Planning Application Ref: P/6/17/OUT

Location: Land North of Hook Lane, Pagham

Description of works: Outline application with some matters reserved for construction of up to 300No. new homes, Care home of up to 80No. beds, D1uses of up to 4000sqm including a 2 form entry Primary School, formation of new means of access onto Hook Lane & Pagham Road, new pedestrian & cycle links, the laying out of open space, new strategic landscaping, habitat creation, drainage features & associated ground works & infrastructure. This application is a Departure from the development plan

Tree Officer / Parks and Greenspace Team

drawing title
**TREE SURVEY PLAN
FIGURE 2**

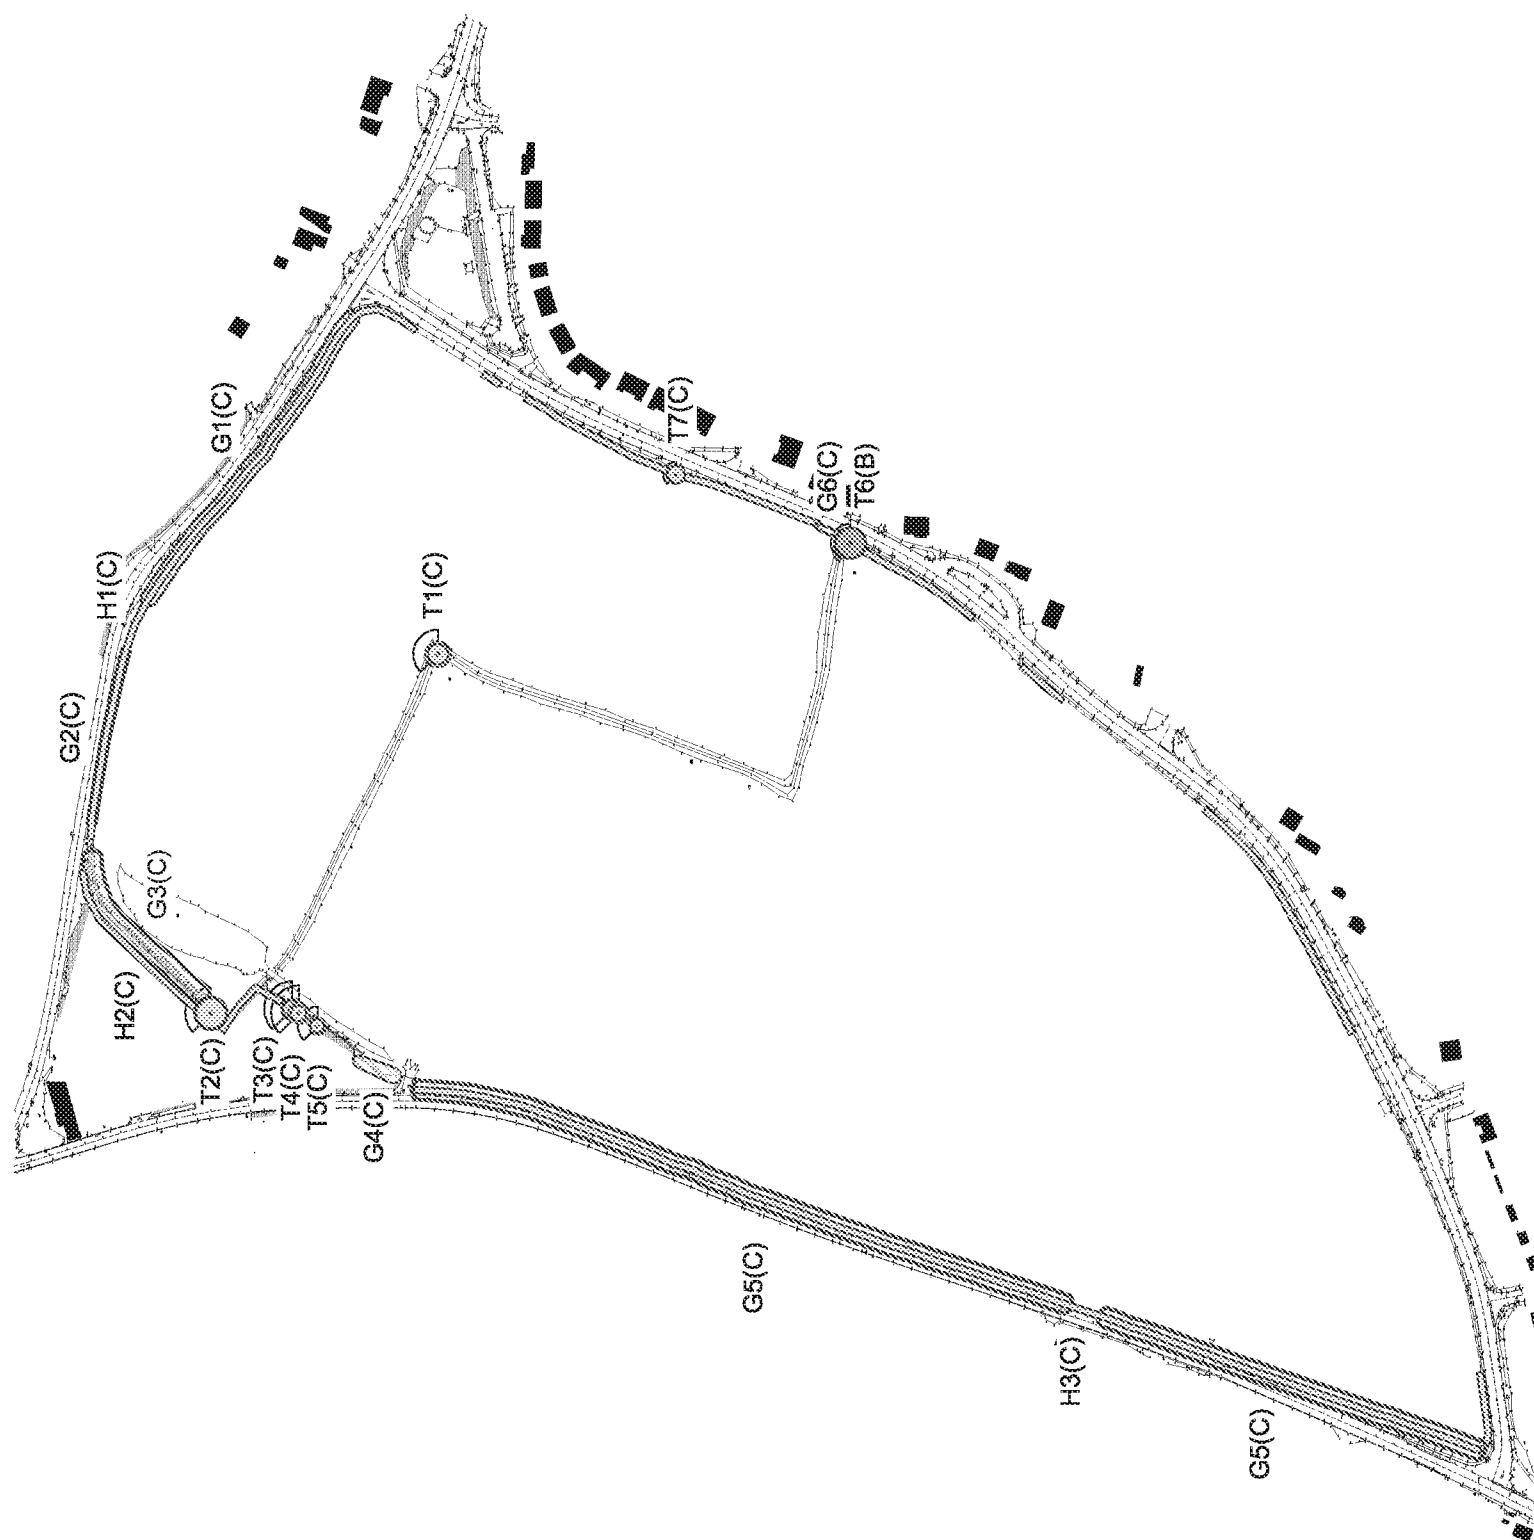
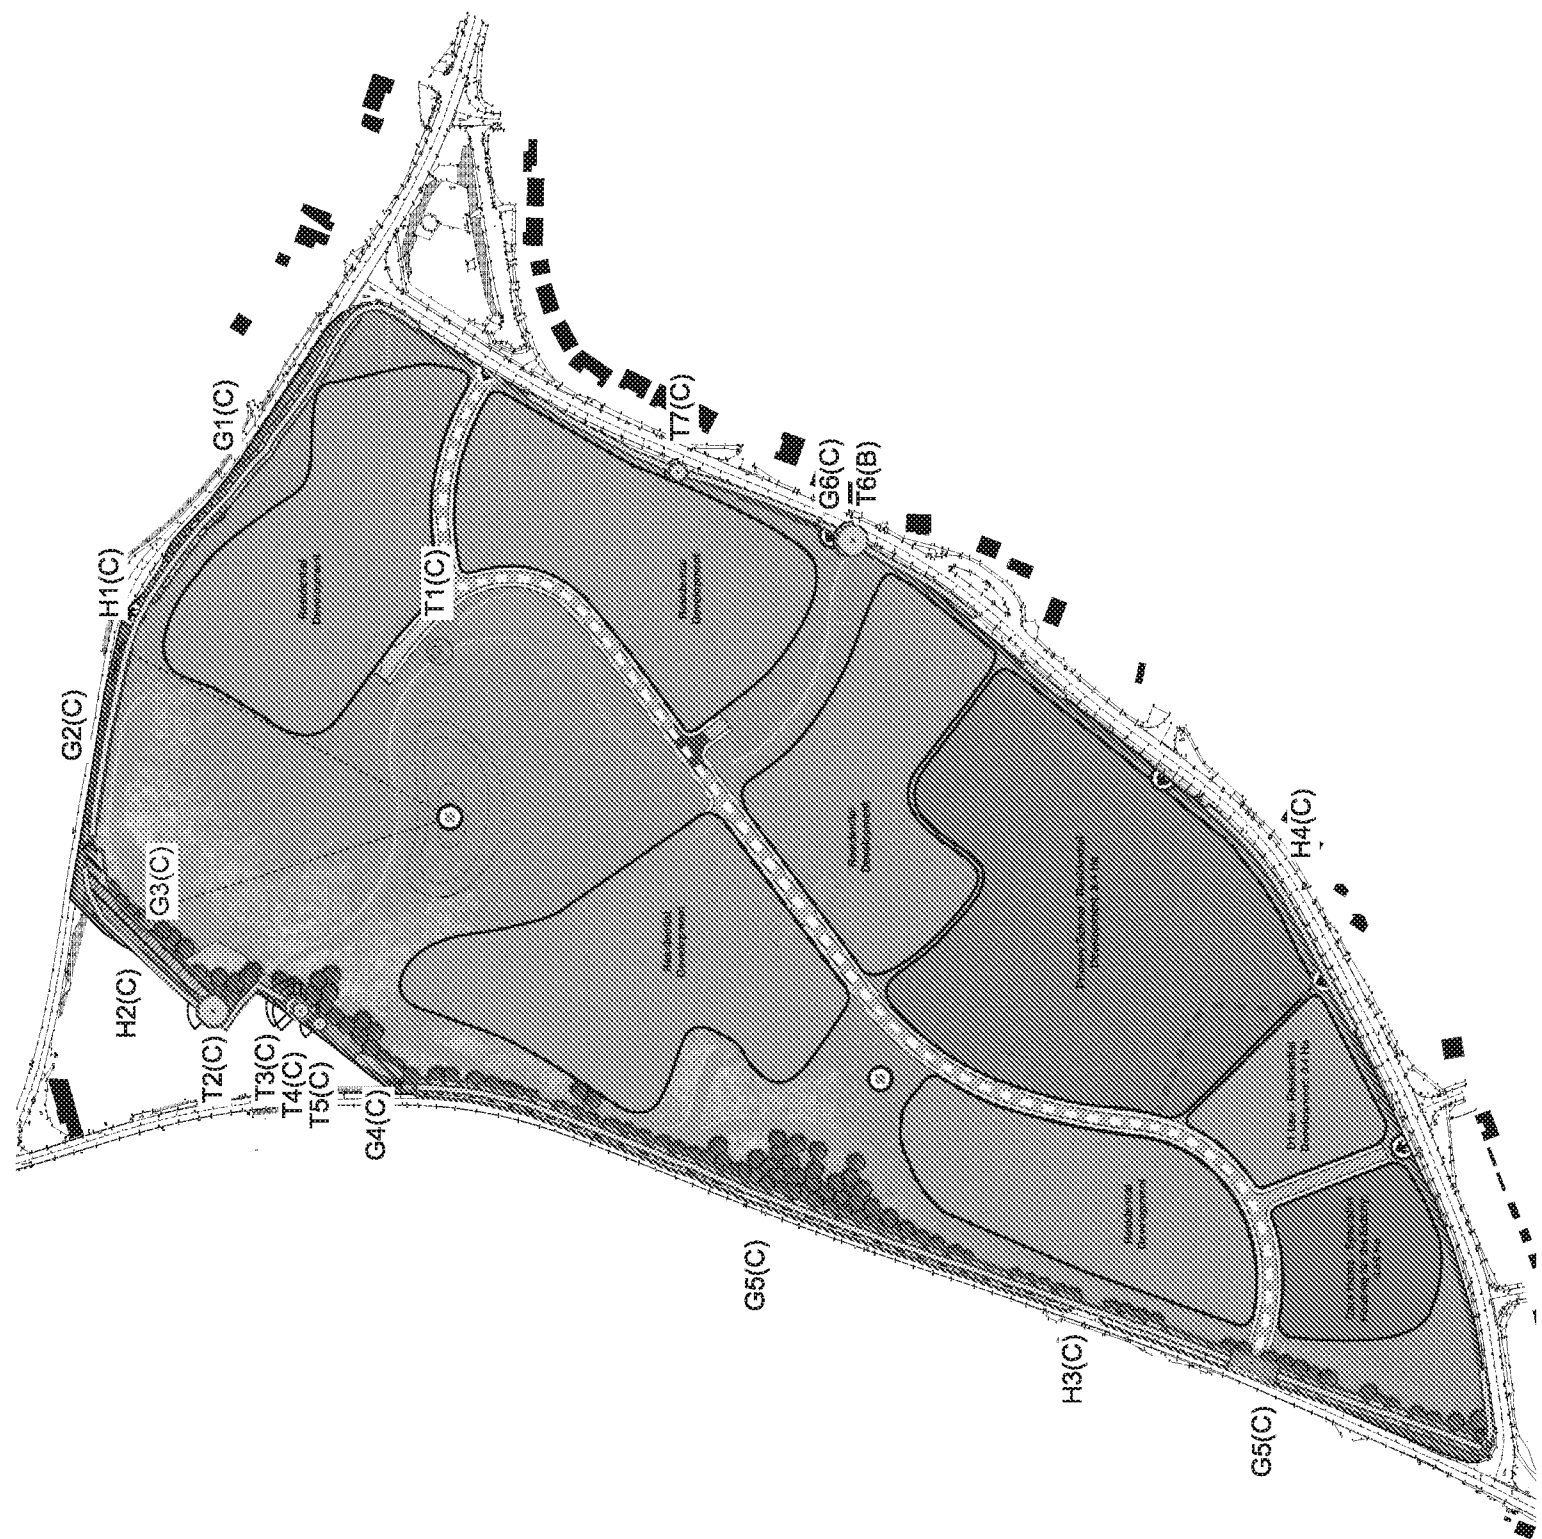
- Hallam Land Management Ltd instructed FPCR Environment and Design Ltd to undertake a tree survey and present an Arboricultural Assessment, dated 03.01.2017. Tree Survey data is adequate and generally accords with the requirements of BS5837:2012, although I believe the hedgerow retention categories, species evaluation and estimated RPAs undervalue their true significance.

- The established native hedgerow and trees within represent an important buffer and screening from adjacent land in addition to being of obvious ecological importance to the area. The extent of sycamore and field maple has not been fully recognised in the survey record for some large sections of hedgerow.

- There is only one tree of sufficient individual merit that qualifies for the making of a Tree Preservation Order – a maturing oak in the hedgeline opposite 60 Hook Lane. It appears to have been respected in the site design layout but it has not yet been demonstrated that it will be adequately protected during development.

- I would like to see an extension of the recorded RPA for hedgerow/trees on the sites W boundary (bordering Pagham Road) to ensure adequate protection throughout any development. I suggest a minimum of 6m to prevent disruption to ground conditions and avoid direct contact.
- I will need to see a detailed Tree Protection Plan that seeks to adequately protect retained hedgerow and trees across the site.
